PLANNING CONSULTATION RESPONSE

Application No	2026/0363
Proposal	Demolition of existing garages and erection of detached dwelling with detached garage and associated works
Address	Land adjacent to 113 Hoyland Road, Hoyland Common, Barnsley
Date of Consultation Reply	04/06/26
Consultee	Highways DC

Project	Detached Dwelling	
Client	Mr Shane O'Keefe	
Title	Detached Garage	
Address	Adj. 113 Hoyland Road, Hoyland Common, Barnsley, S74 0AP	
Drawn By	GGG	
Scale	Scales @ A3	Date Apr 26
Drawing No	531-10	Rev

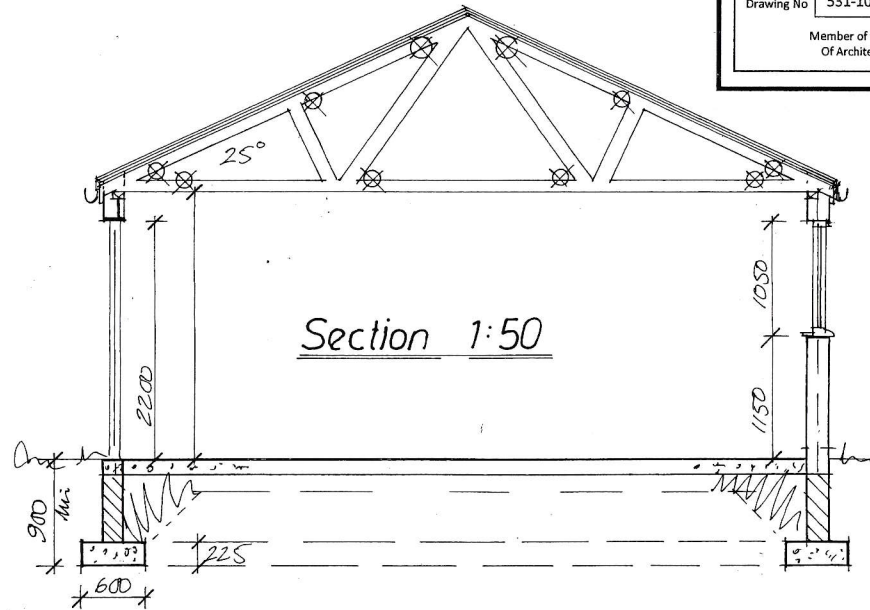
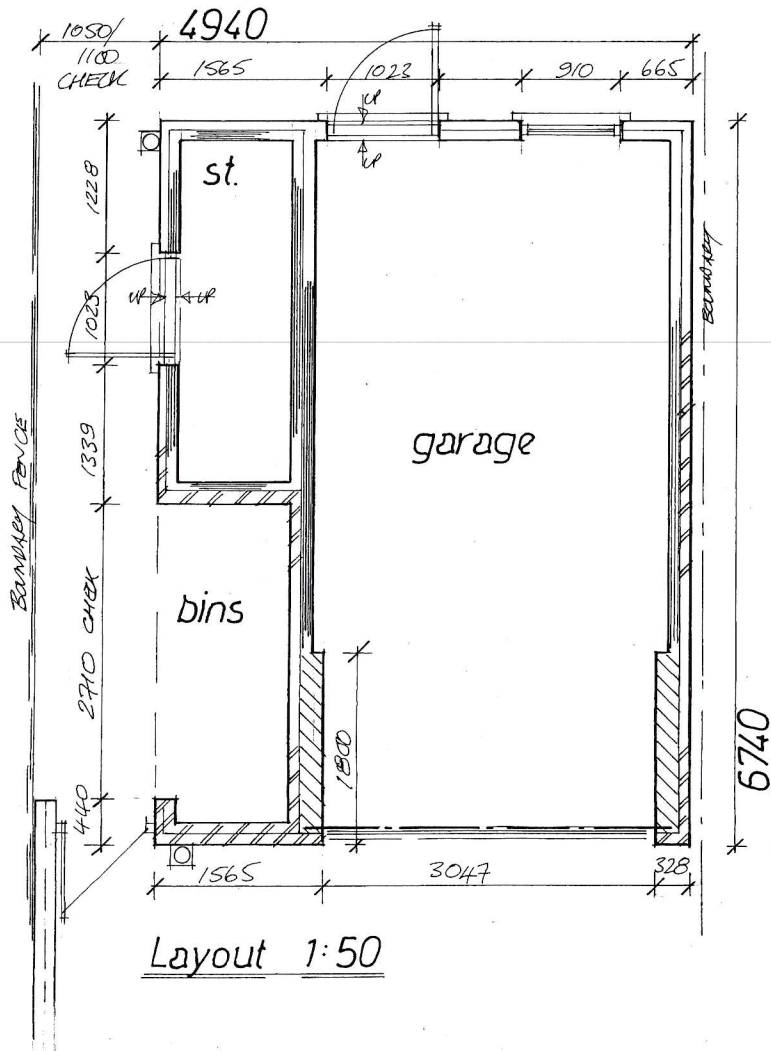
The proposal would create a three-bedroomed bungalow that would be furnished with a single garage and a driveway able to accommodate at least one vehicle. Bin and cycle storage spaces are shown in drawing no. 531-10 to be attached to the garage.

Project	Detached Dwelling	
Client	Mr Shane O'Keefe	
Title	Site Layout	
Address	Adj. 113 Hoyland Road, Hoyland Common, Barnsley, S74 0AP	
Drawn By	GGG	
Scale	1:200 @ A3	Date Apr 26
Drawing No	531-01	Rev

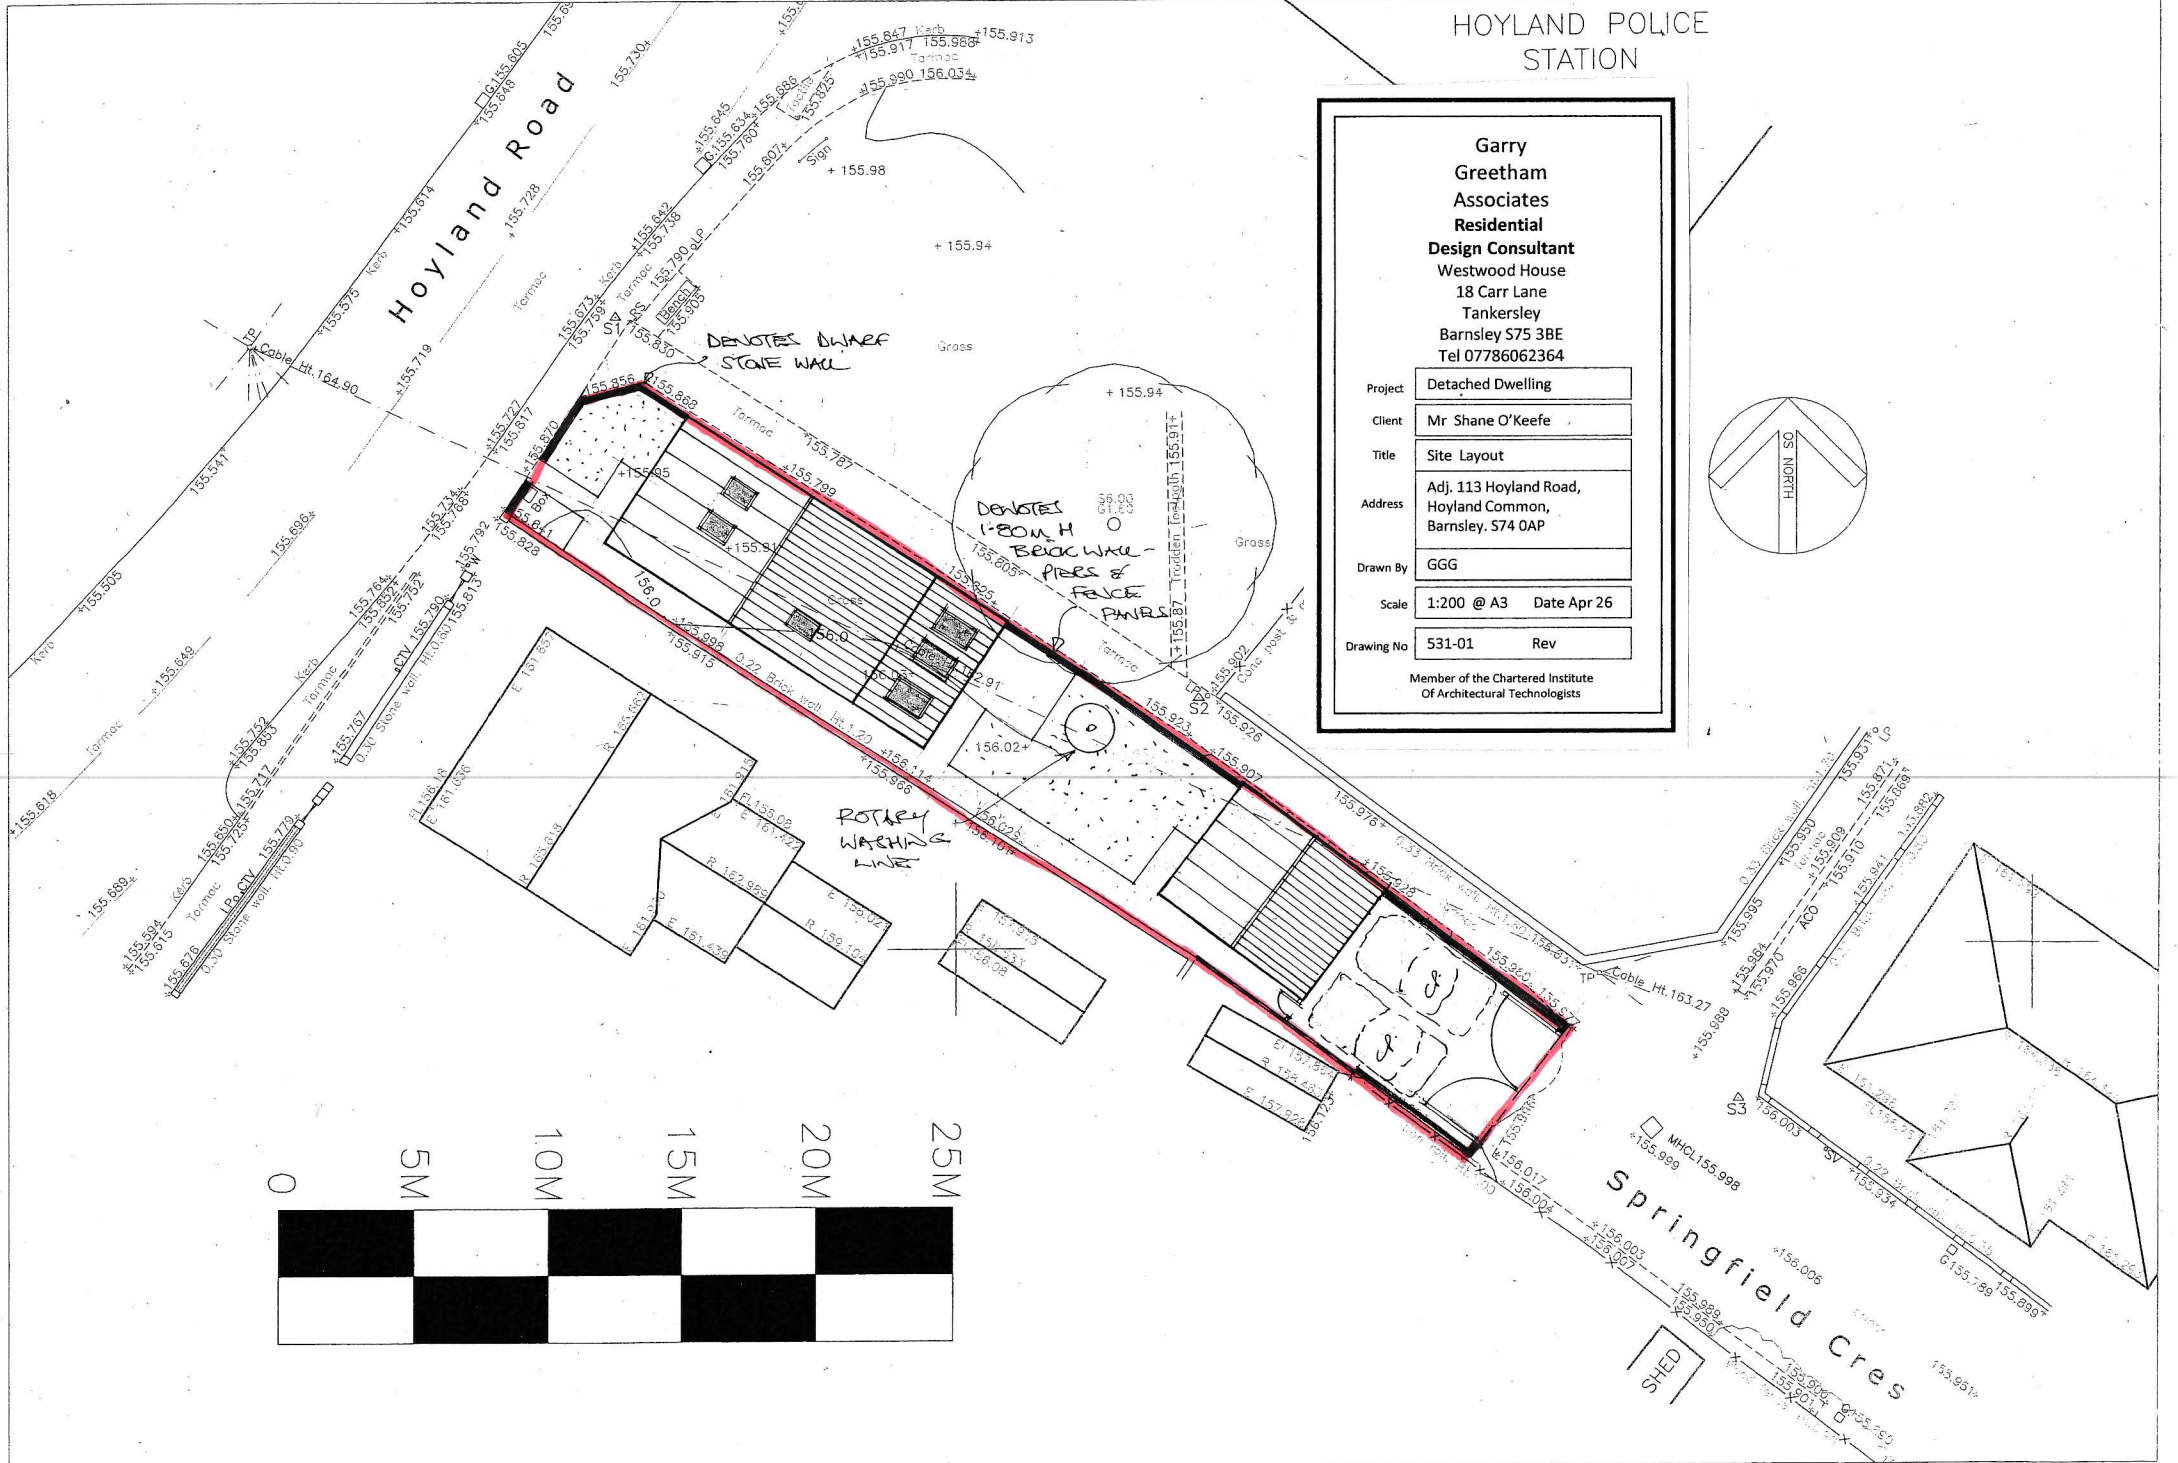
Access is taken from Springfield Crescent as per the advice given prior to the land being sold. Pedestrian access is maintained between Springfield Crescent and Hoyland Road.

The parking facilities as indicated on the submitted plan shall be surfaced in a solid bound permeable material (i.e. not loose chippings) and adequate measures shall be so designed into the proposed access to avoid the discharge of surface water from the site on to the highway.

The parking facility hereby permitted shall not be brought into use until pedestrian visibility splays of 2m x 2m to the back edge of the footway have been provided at the proposed access. Nothing shall be erected, retained, planted and/or allowed to grow at or above a height of 0.6m to the rear of the footway which would obstruct the visibility splays. The visibility splays shall be maintained free of obstruction at all times thereafter for the lifetime of the development.

Any gates shall be set back from the edge of the public highway and designed to only open inwards and be permanently retained as such. When in an open position, the pedestrian visibility splays of 2m x 2m shall remain safeguarded such that there is no obstruction to visibility at a height exceeding 600mm above the nearside channel level of the adjacent highway.
